OXFORDSHIRE COUNTY COUNCIL'S RESPONSE TO CONSULTATION ON THE FOLLOWING DEVELOPMENT PROPOSAL

Application no: 23/01493/REM

Proposal: Reserved Matters Application including access, layout, landscaping and scale pursuant to outline planning permission 14/02121/OUT for internal primary and secondary streets along with the partial discharge of conditions 12 (Building for Life 12), 16 (means of vehicular access), 17 (means of pedestrian/cycle links) and 19 (detailed surface water drainage scheme) for Phase 1B

Location: Proposed Himley Village North West Bicester, Middleton Stoney Road, Bicester

TITLE
PHASE 1B
BUS SWEPT PATH ANALYSIS
SHEET 2

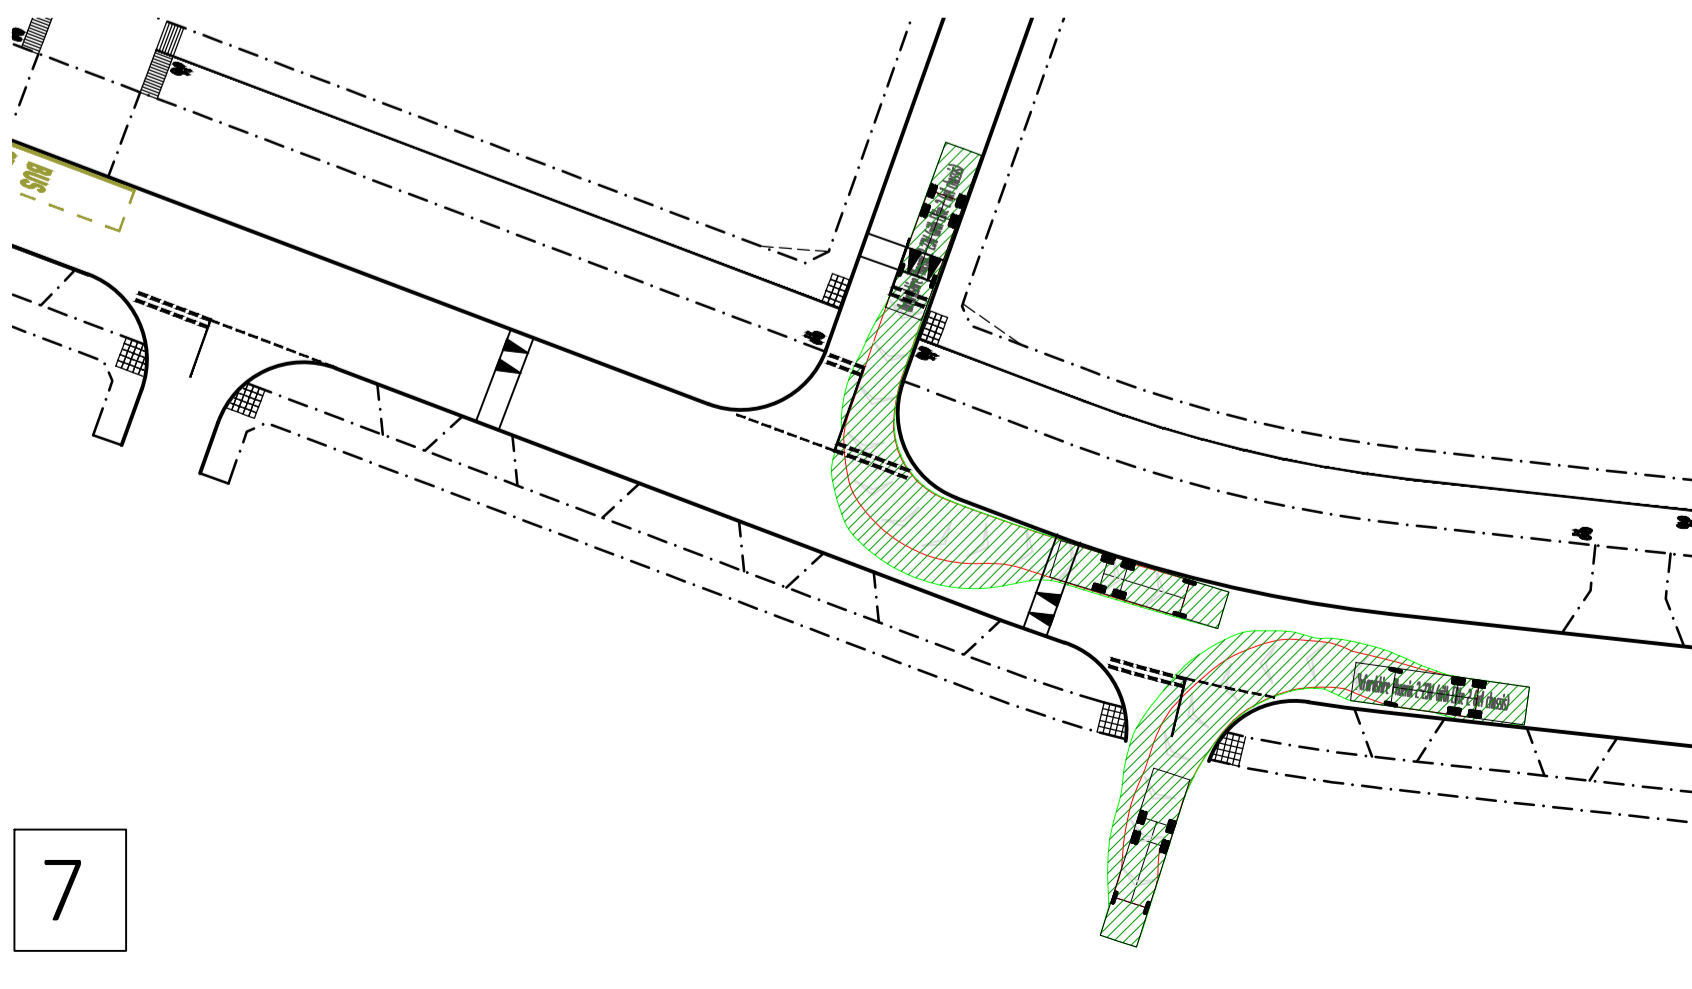
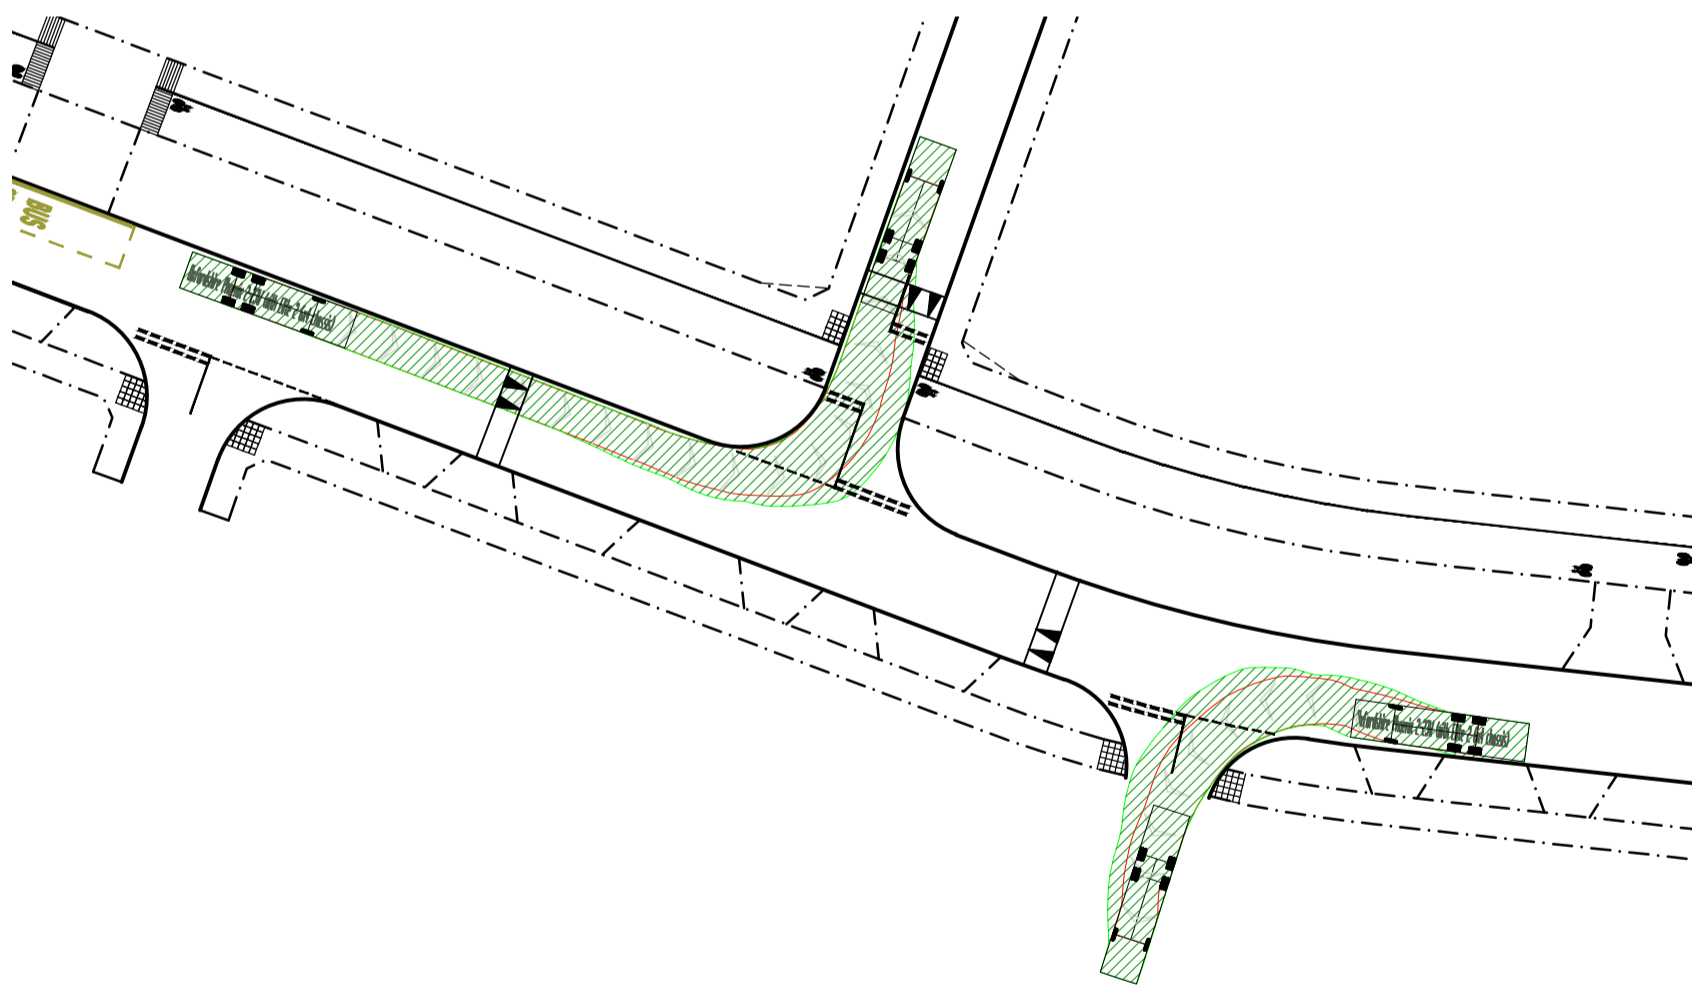
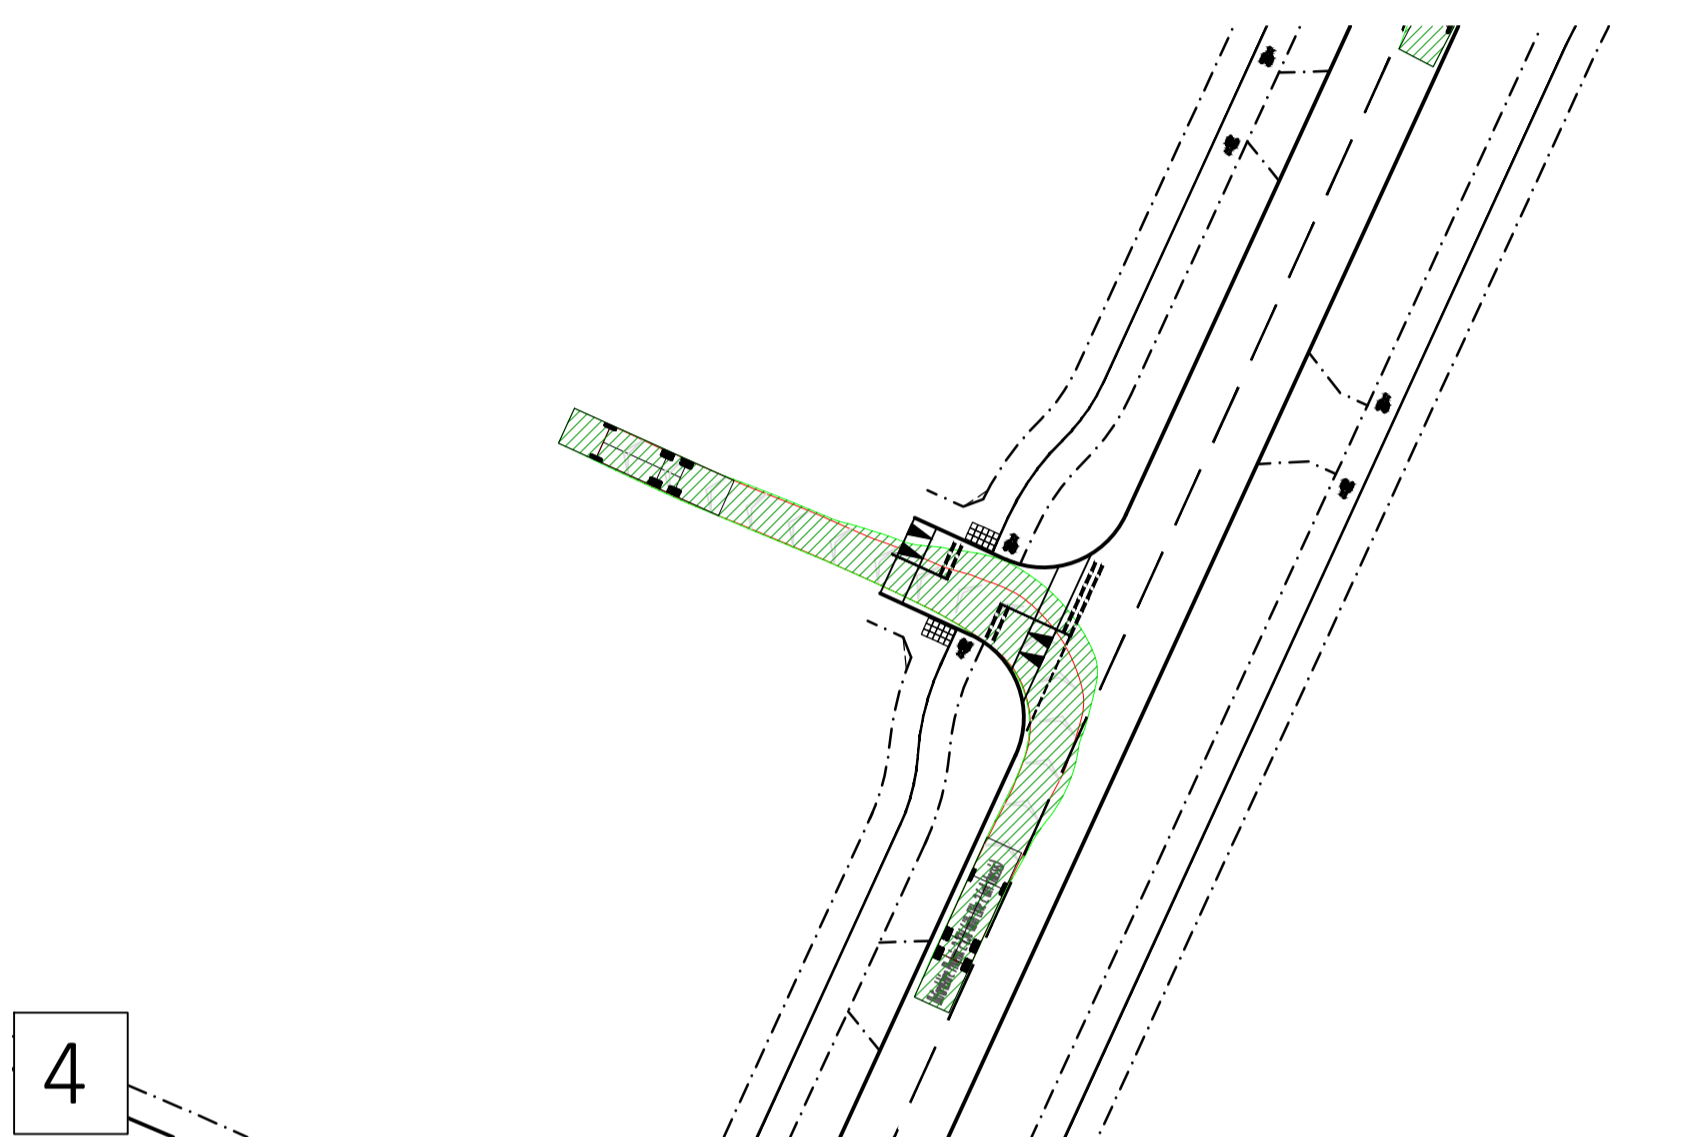
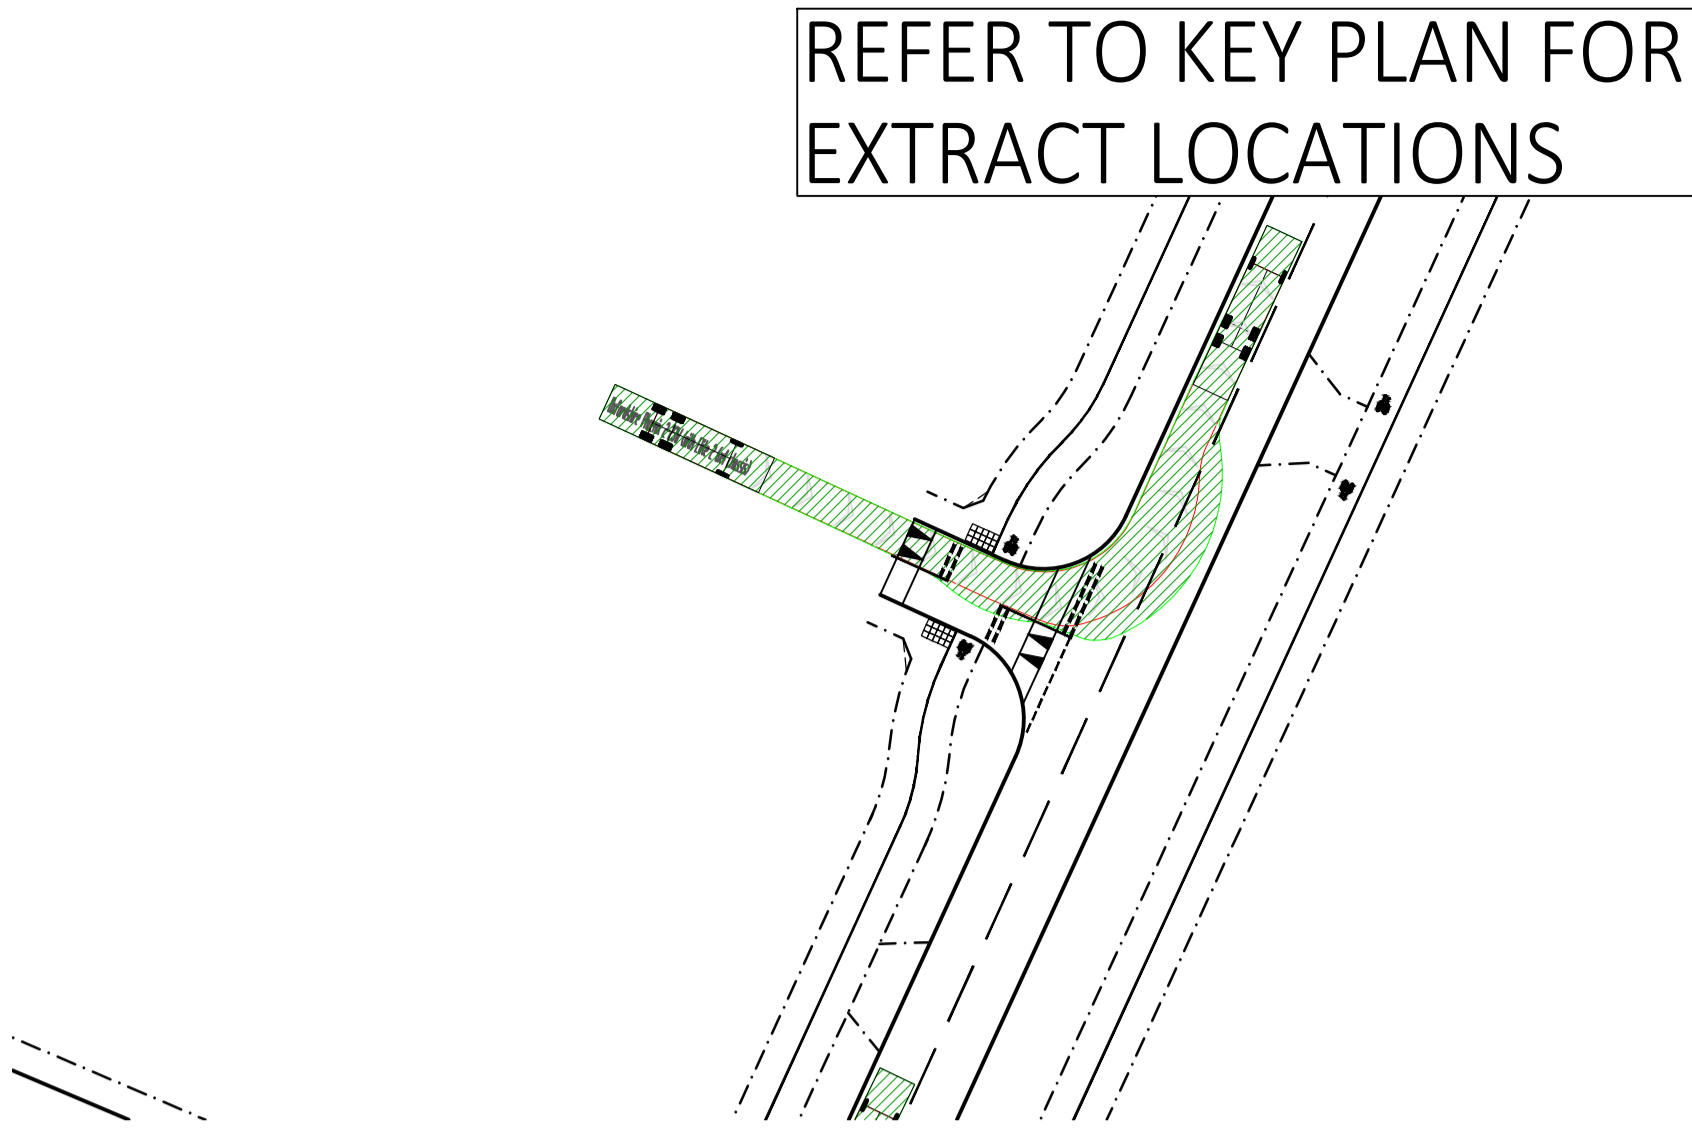
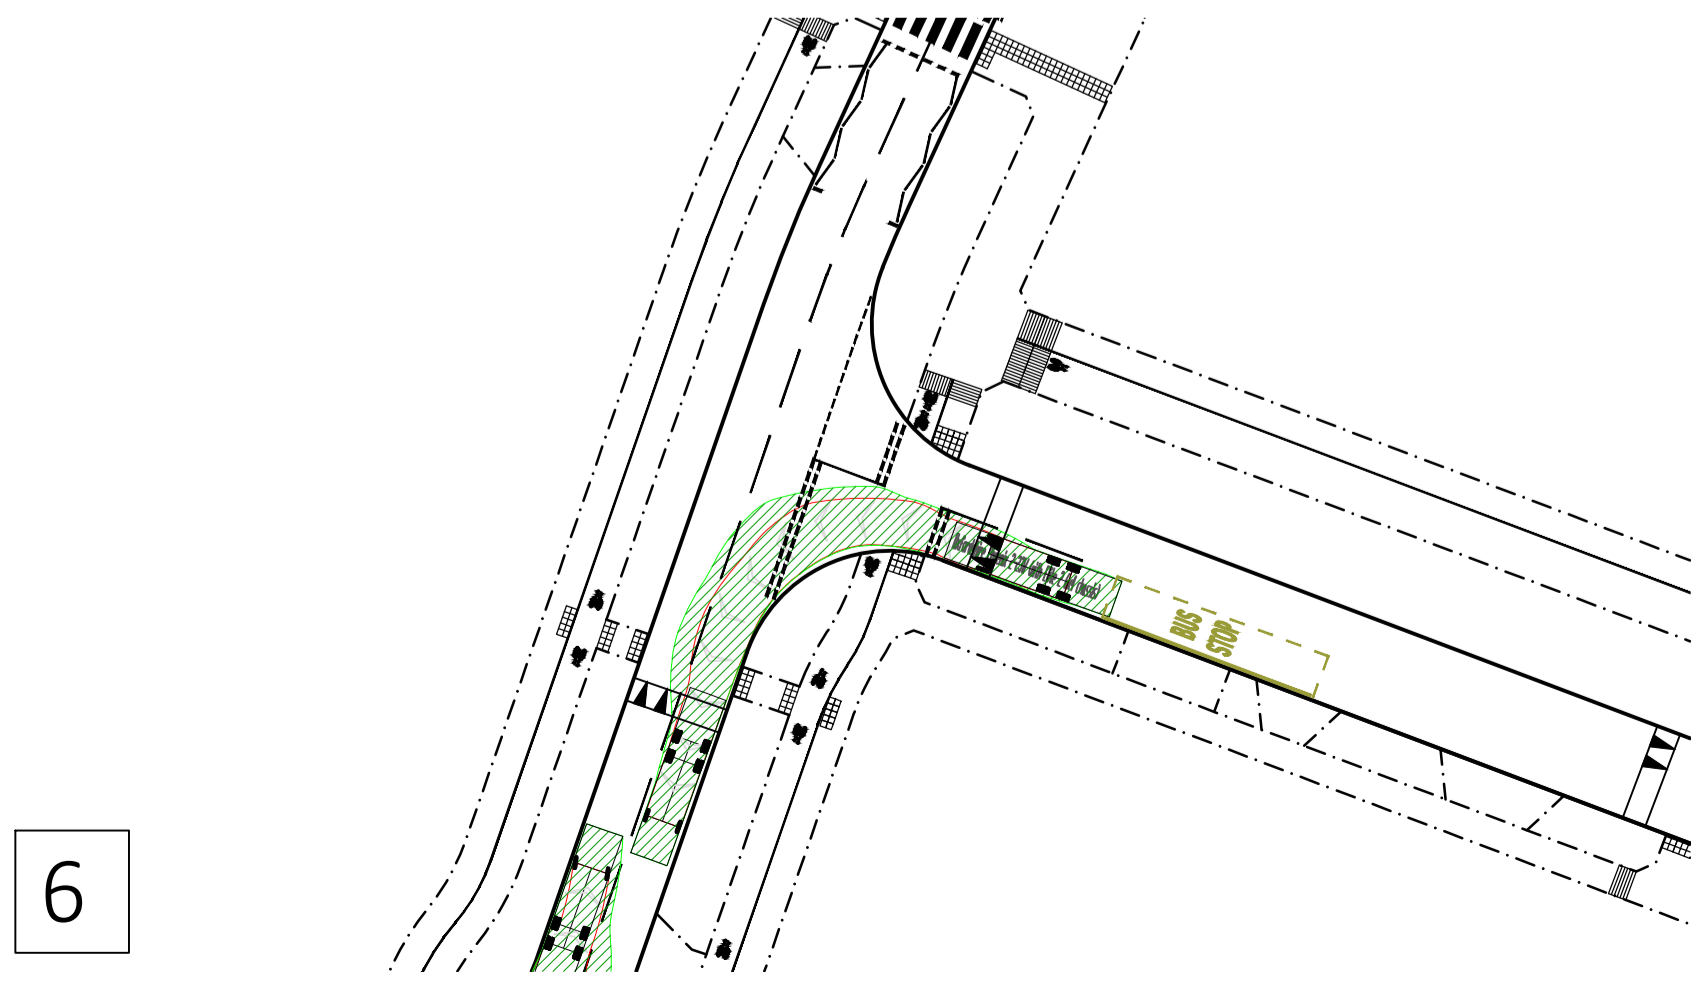
I previously explained that the temporary bus turning heads were not acceptable as it would require buses reversing over the raised cycle crossings. After discussions with the applicant, it has been agreed that the raised cycle crossings at the northern end of the Spine Road North - South and at the eastern end of the Spine Road East - West will be implemented when Oxfordshire County Council have confirmed that the requirement for the use of the temporary bus turning heads has ceased.

In addition, the raised crossings at the western end of the strategic secondary streets will be implemented when these roads connect to Phase 3 and Oxfordshire County Council have confirmed that the temporary turning heads are no longer required. Insets on the Engineering Layout Sheets 1 to 4 include the layout of all the temporary turning head as well as the agreed final layout.

In accordance with the approved Phase 1B Engineering Layout Sheets 1 to 4 (dwg nos 27141-HYD-1B-XX-DR-C-2200/P09, 27141-HYD-1B-XX-DR-C-2201/P10, 27141-HYD-1B-XX-DR-C-2202/P10, 27141-HYD-1B-XX-DR-C-2203/P09) works associated with the temporary bus turning heads shall be constructed and remain in place until Oxfordshire County Council have confirmed that the temporary turning heads are no longer required. The final road layout as shown on the approved plans, including raised tables and all road markings, shall be completed within 6 months of the final use of the temporary turning heads unless otherwise agreed in writing with the Local Planning Authority.
